# HAYES STRUCTURAL

**Date:** October 29, 2024

**Re:** 24-FRM-129  
Framing Inspection  
Lot 230 Serenity  
72 Charming Court  
Fuquay-Varina, NC 27526  
Permit No.: SFD2408-0046

<p>Copyright © 2022 (2022) The Drees Company. All Rights Reserved. 7701 Six Forks Road, Suite 132, Raleigh, NC 27615 Phone: [919] 844-9288</p>	<p>Sheet Information</p>	<p>1.01S</p> <p>Foundation Plan (Slab) Elevation "A"</p>

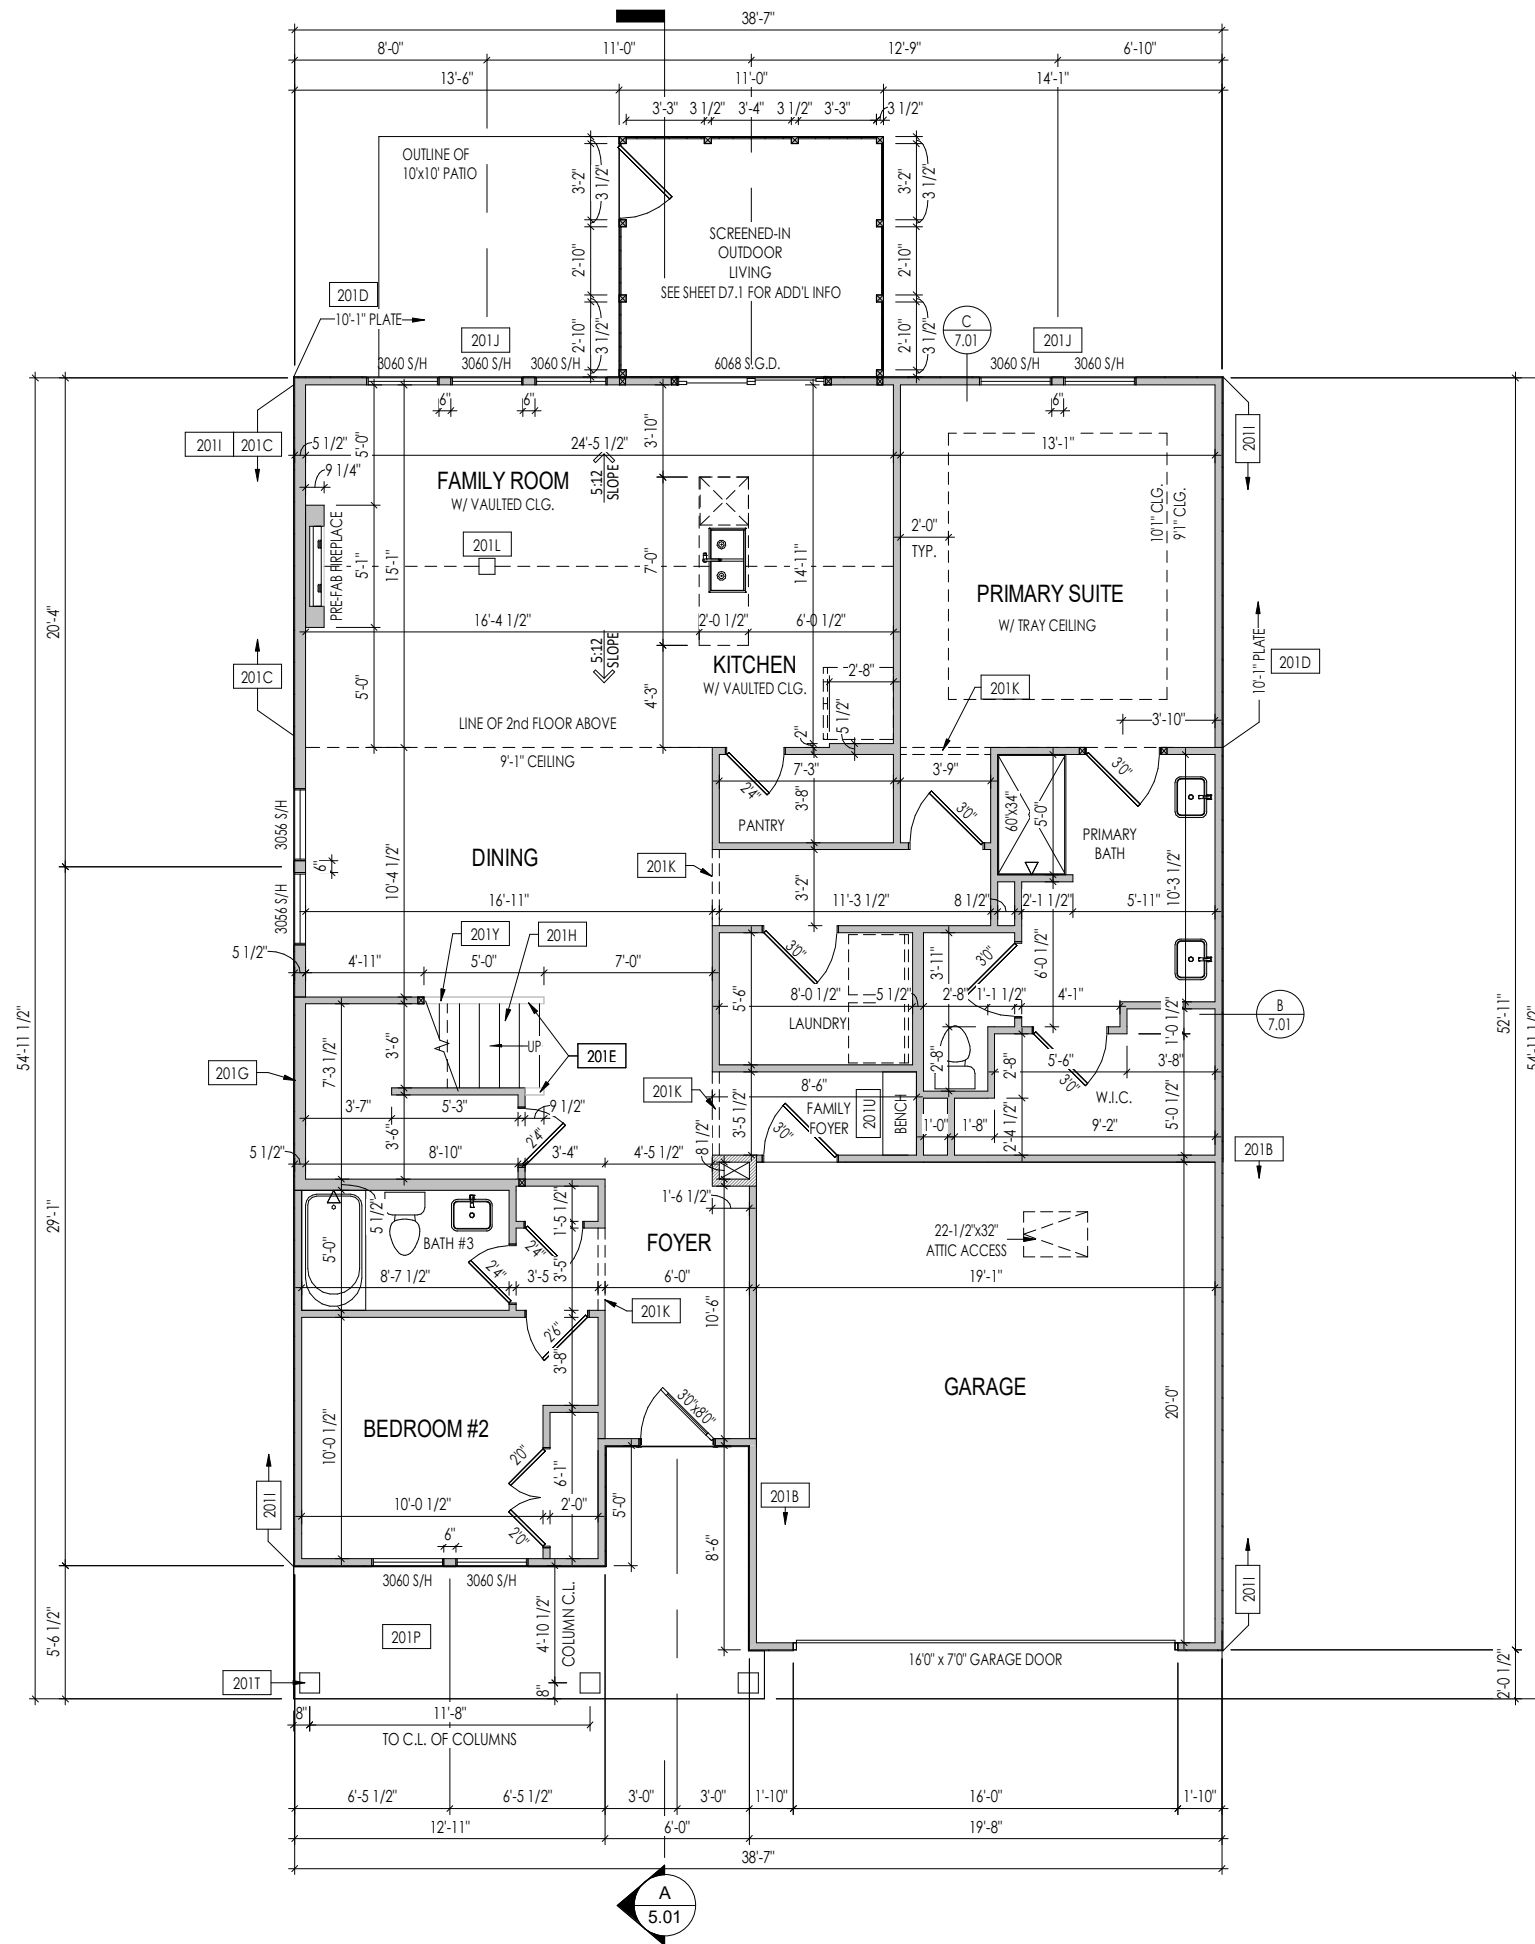
At your request, a site visit was made to the above referenced single family residence under construction to inspect the sole plate between the garage and foyer noted by the inspector to lack full bearing on the foundation.

The 2x4 sole plate was measured to cantilever over the foundation ranging from +/- 1" to +/- 1/4" from the foundation jog towards the left rear corner of the garage.

Analysis revealed portions of the sole plate cantilevered up to 1/2" over the foundation are adequate and do not require additional support. Support the front end of the cantilevered sill plate with a 5/4x6 or 2x4 pressure treated block installed beneath the first two studs from the foundation jog. Install the blocks tightly between the garage slab and plate and attach the blocks to the foundation with (4) equally spaced 3/16" diameter by 2 3/4" long Tapcon (or equivalent) concrete screws. The cantilevered sole plate supported in the above noted manner will provide the required support for all imposed loads.
